**From:** Rachel . <blparishclerk@outlook.com>  
**Sent:** 13 February 2024 08:07  
**To:** Planning  
**Subject:** 3/2024/0061

Following consultation with the parish council, the following objections and concerns have been raised.

Route to the site along the A666

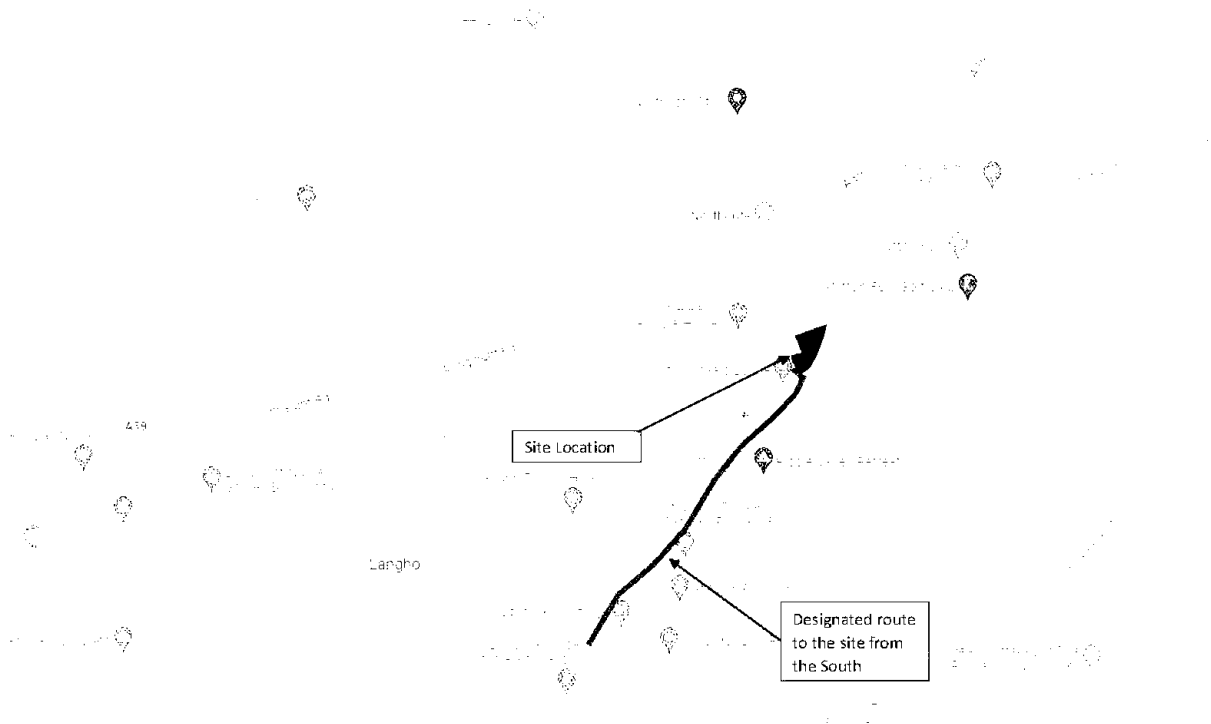
Construction traffic to and from the site should NOT approach from the south , as this involves using the main commercial street (often congested by parked cars during the working day) in Langho and passage under a low bridge – all access should be off the A59 via the roundabout.
